Frodsham Solar

Applicant Response to Local Impact Report

PINS Ref: EN010153

Document Ref: EN010153/DR/8.29

Drawing file: published-documents / EN010153-000101-6.2_ES Vol 2 Appendix 2-1 Indicative Watercourse Crossing Schedule.pdf

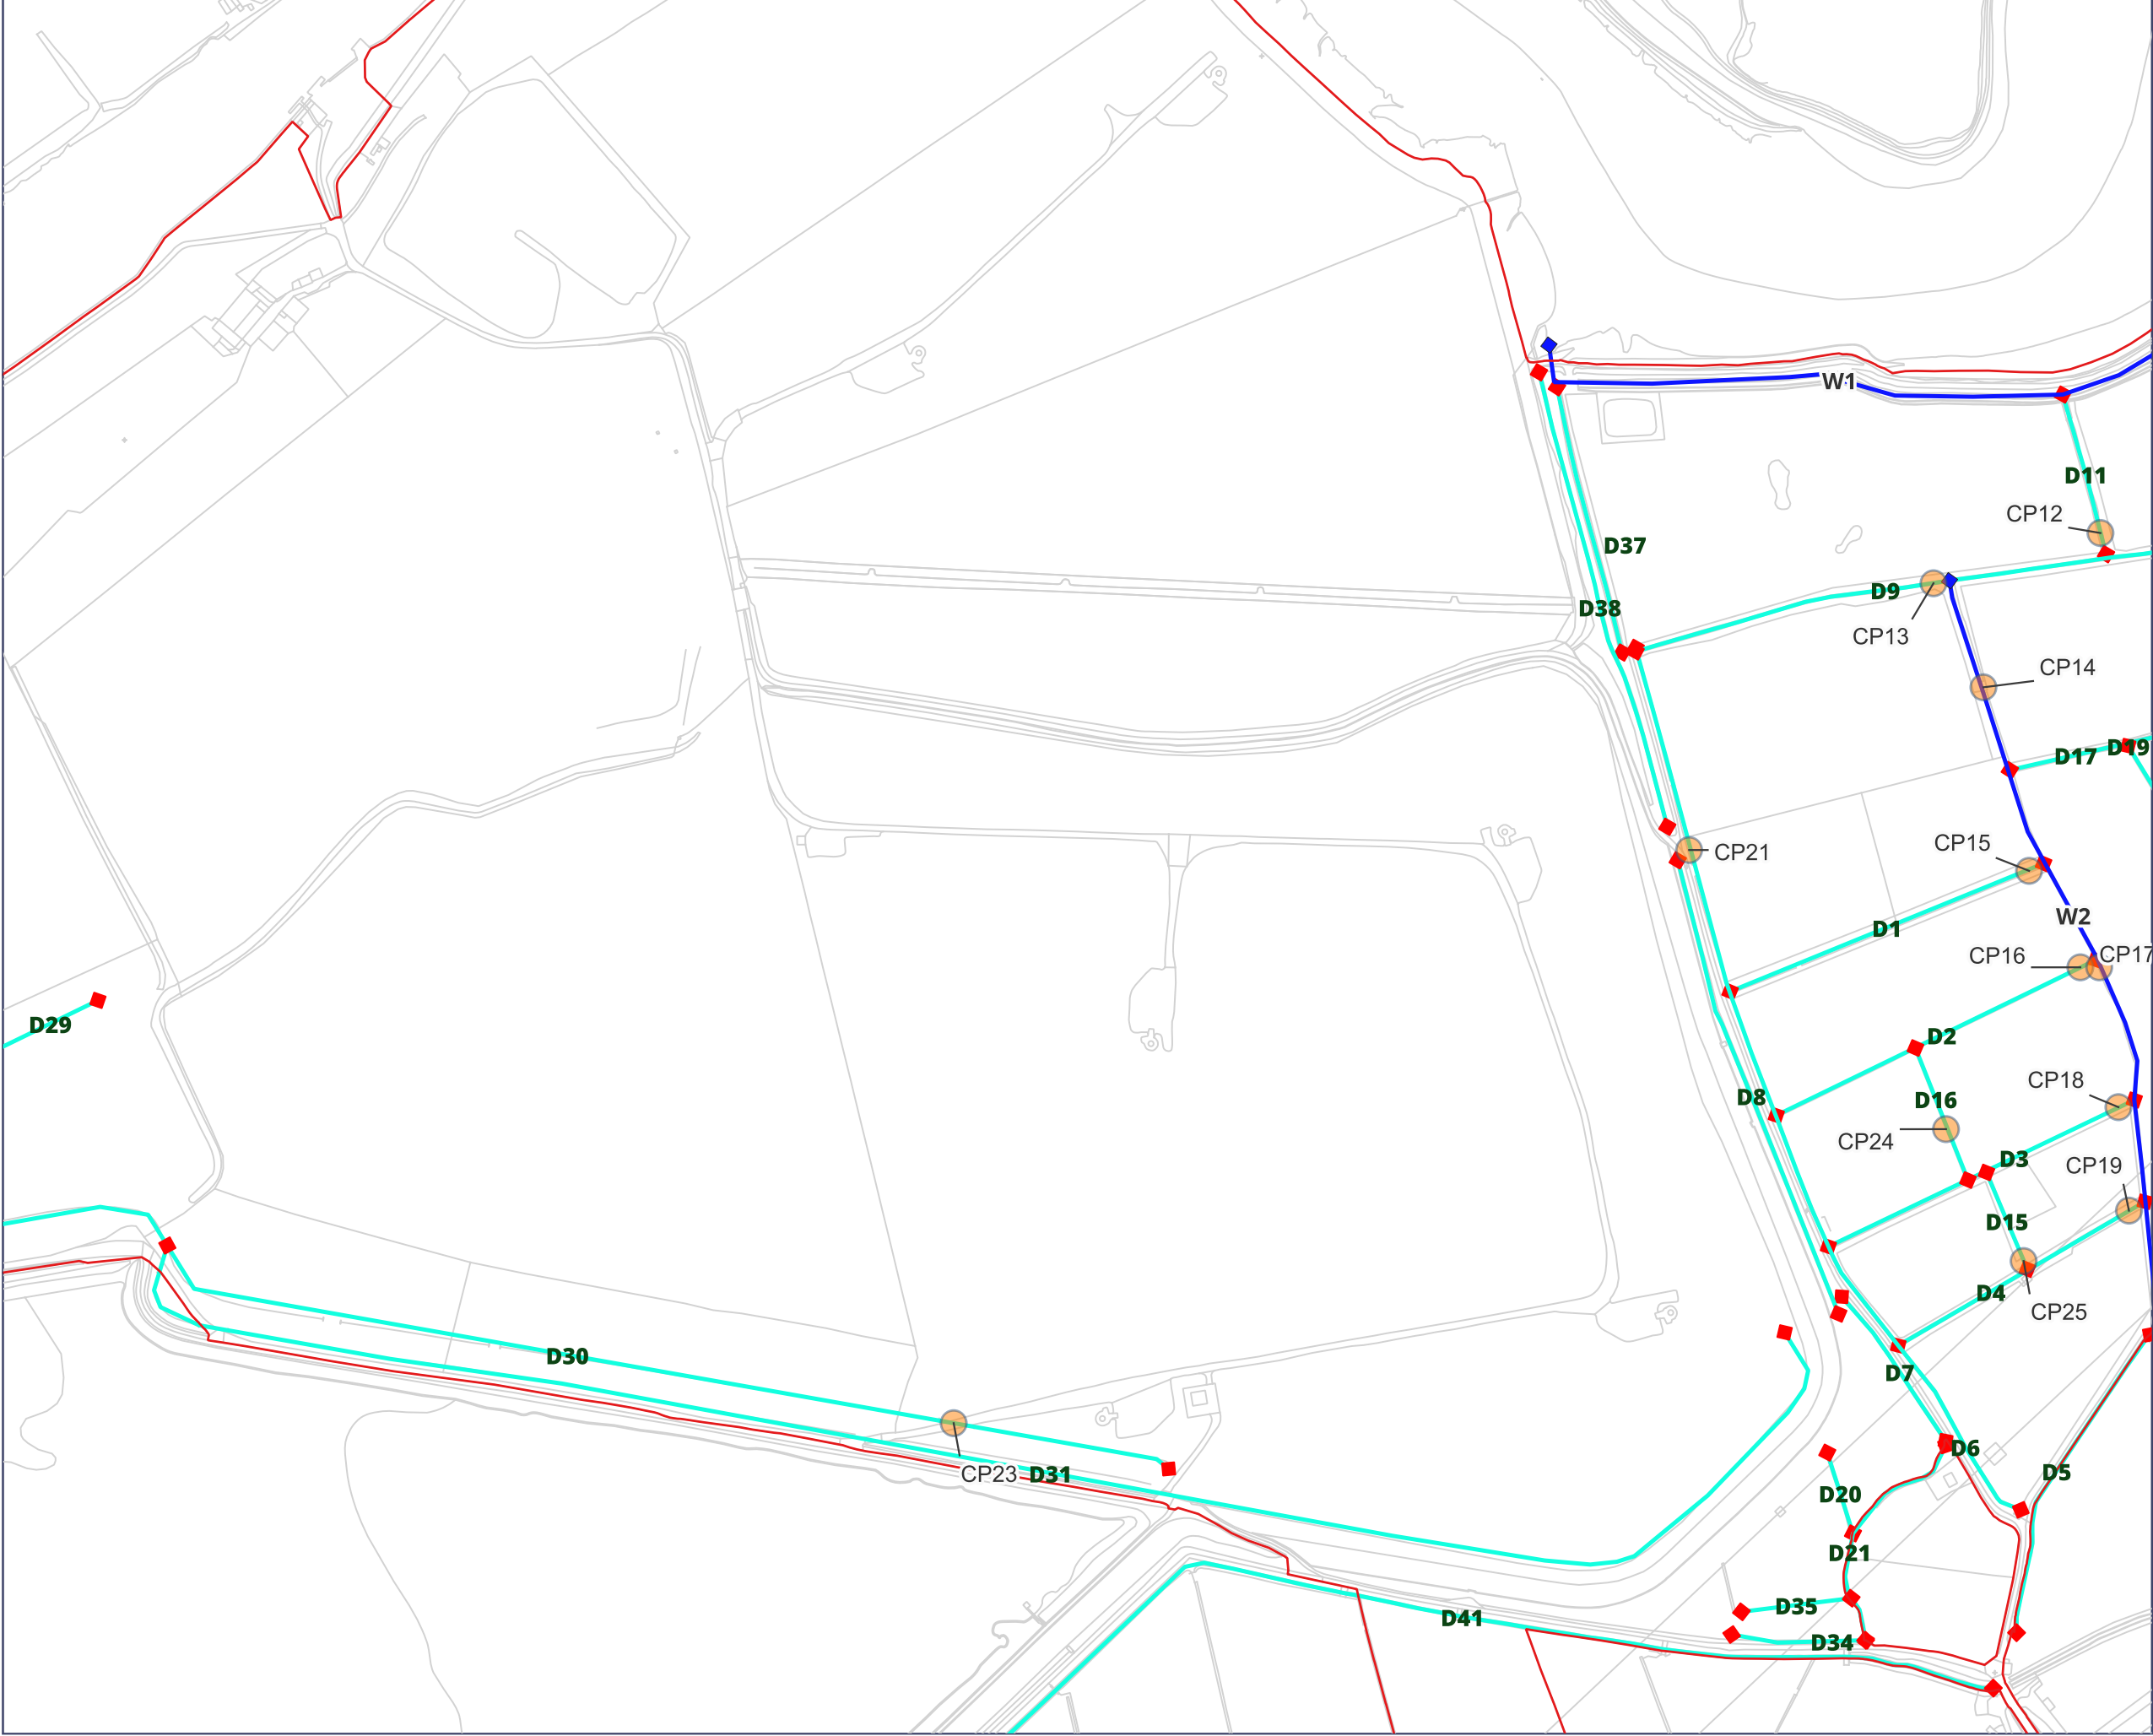
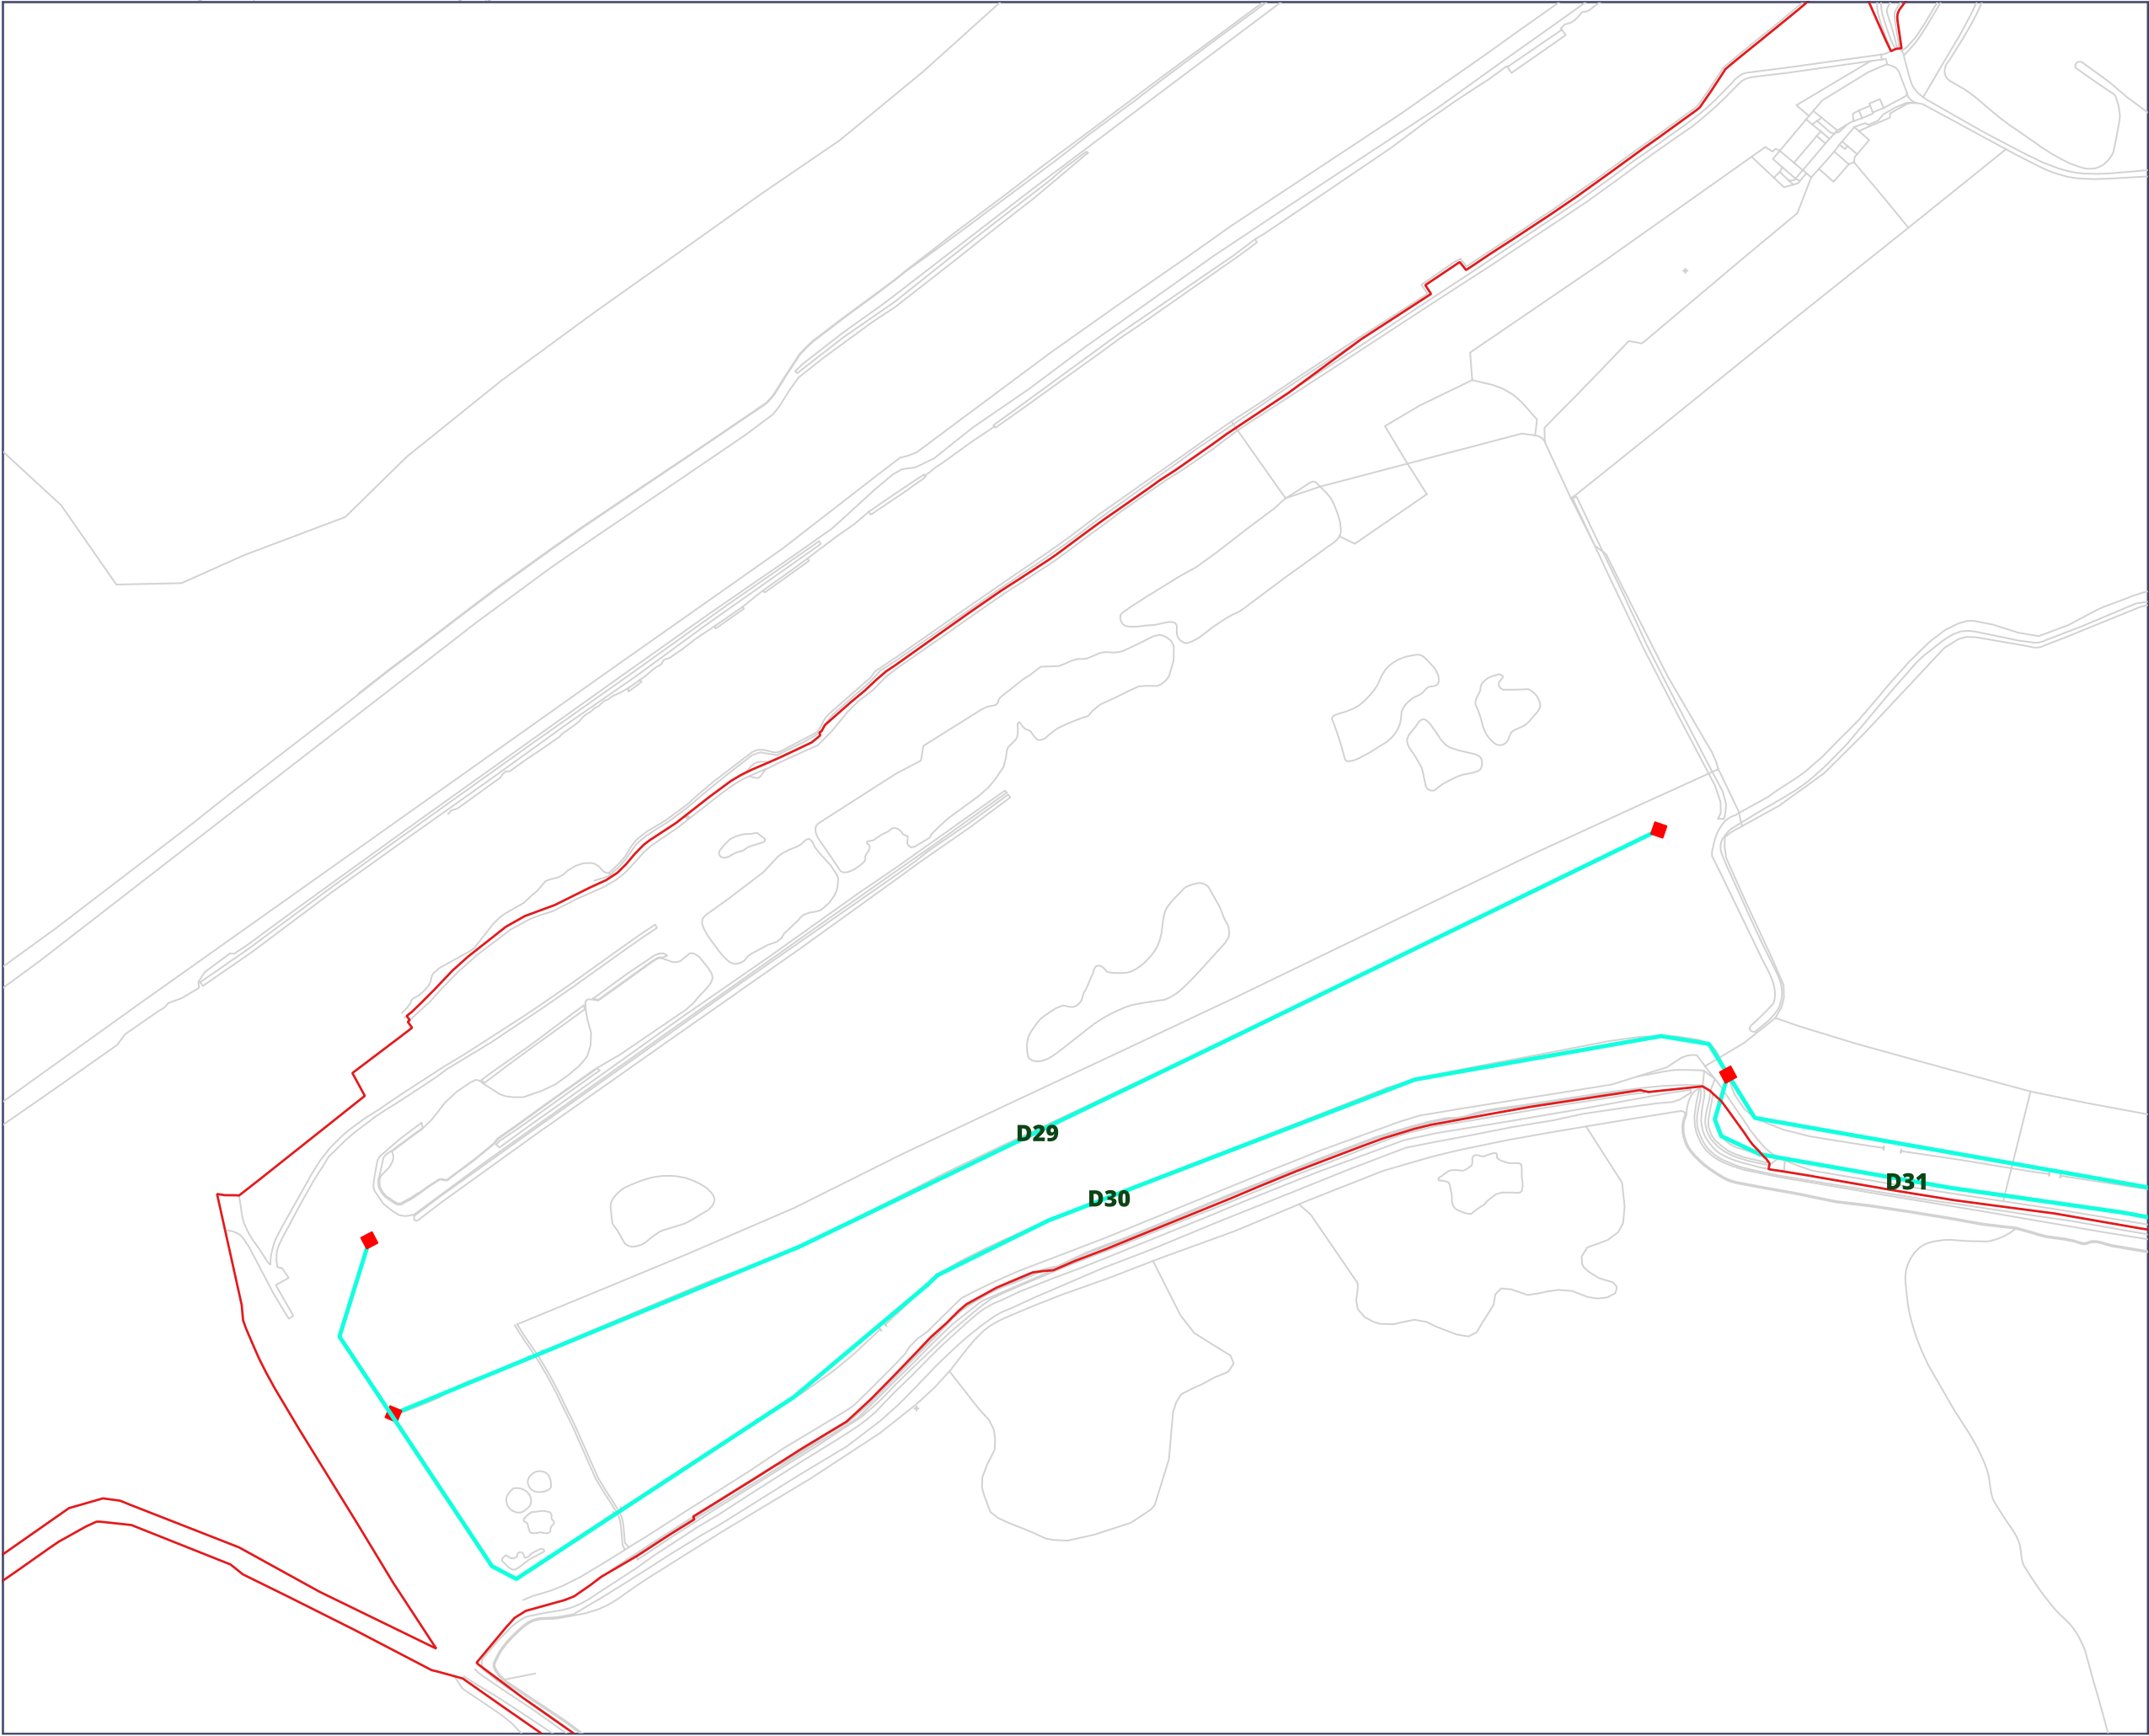
Water Environment – Mersey Estuary, River Weaver - areas of flood risk			
LIR_CWACC2.2	2.14	It is noted that no crossing point is shown for access to the SMA on the indicative watercourse crossings point plan (Appendix K of APP-084) and D41 is not identified as a Main river.	The Applicant acknowledges that the access point into the SMA is not shown as a crossing point on Appendix K of APP-084 or Environmental Statement: Volume 2 Appendix 2-1: Indicative Watercourse Crossing Schedule (inc. figures) [APP-050] . However, the

Ref	Paragraph Number	Comment	Applicant's Response
			Applicant confirms that there are no construction works proposed in the SMA and it is simply a revision to 'Other neutral grassland'. As such the field would continue to be managed using conventional farming practices, with access provided for farm machinery via the existing agricultural access point over the watercourse. No changes to this crossing are proposed.
